MEMORANDUM

TO: Shukria Wiar, Planner
FROM: Lauren Swett, PE
DATE: July 20, 2016
RE: 70 Anderson Street, Level III Site Plan Application

Documents Reviewed by Woodard & Curran

L1.0

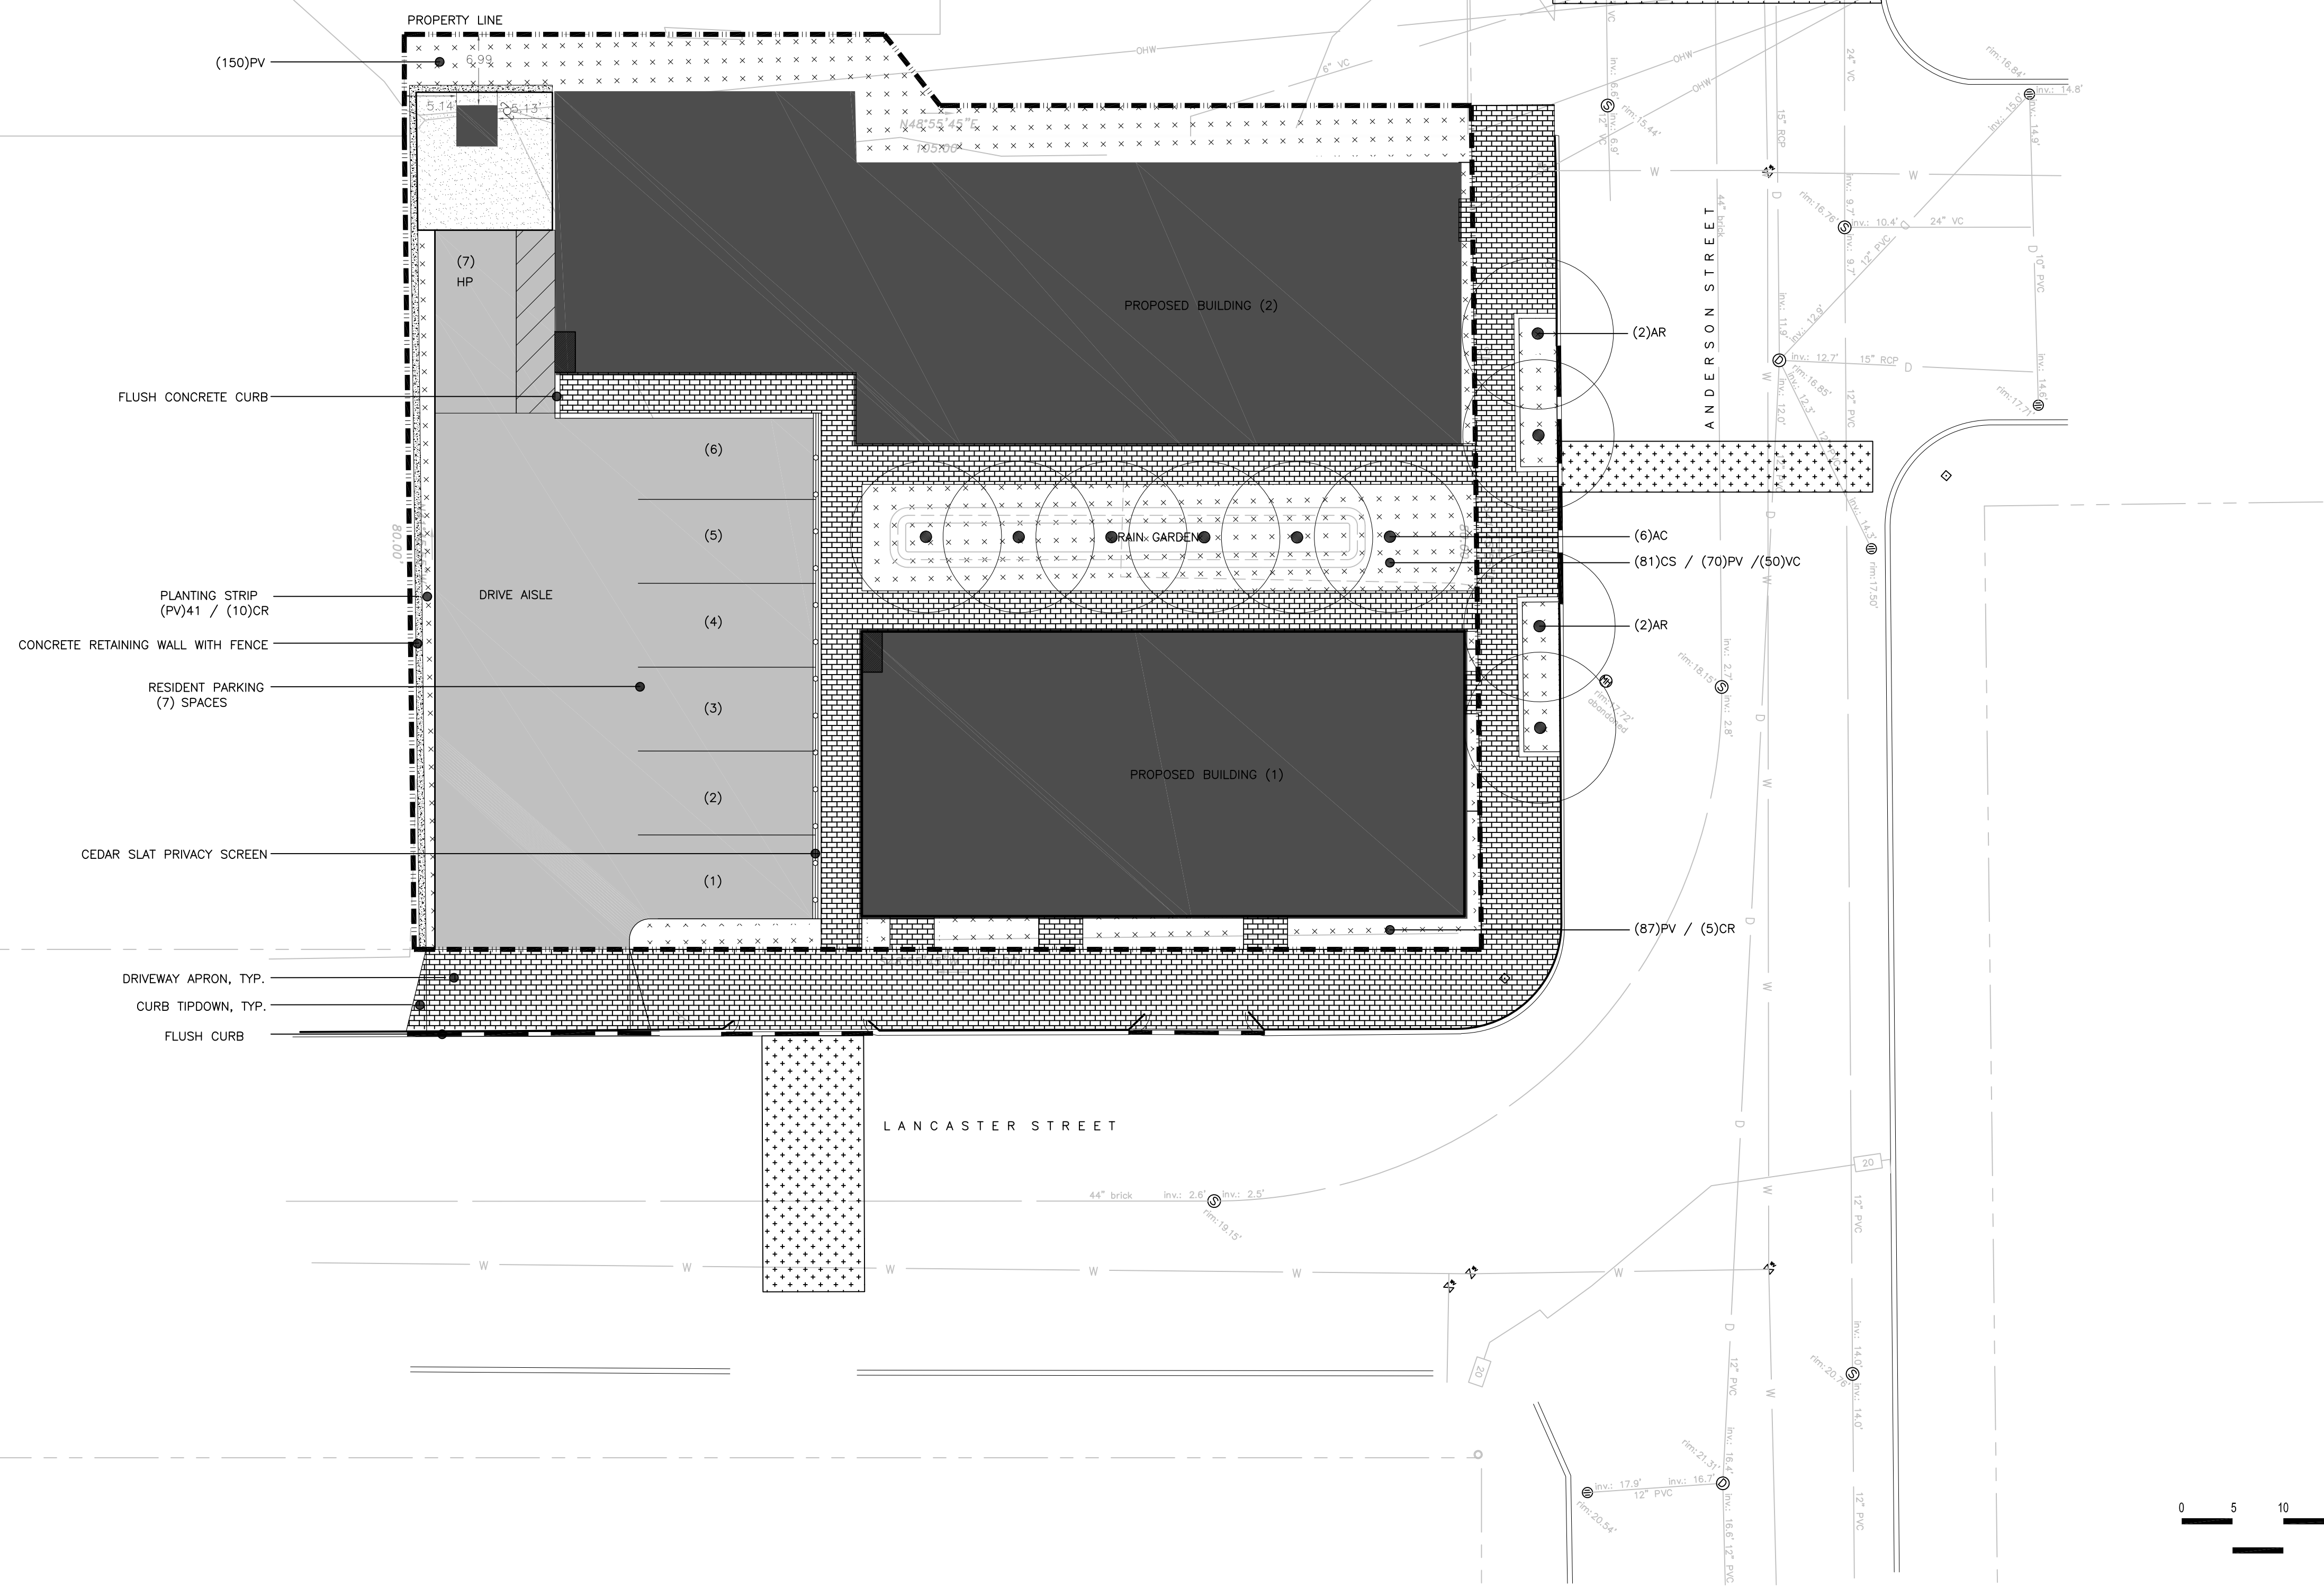
- 8) The rain garden is shown with numerous sewer and water service crossings. The Applicant should verify that these utility pipes will be adequately deep beneath the rain garden system to provide for adequate frost protection. The landscaping plan identifies serviceberry as the trees planted within the raingarden. The Applicant should verify that these plants will not be in conflict with the utility crossings. The pipe trench detail included in the plans notes that no trees should be planted within five feet of a sewer pipe.
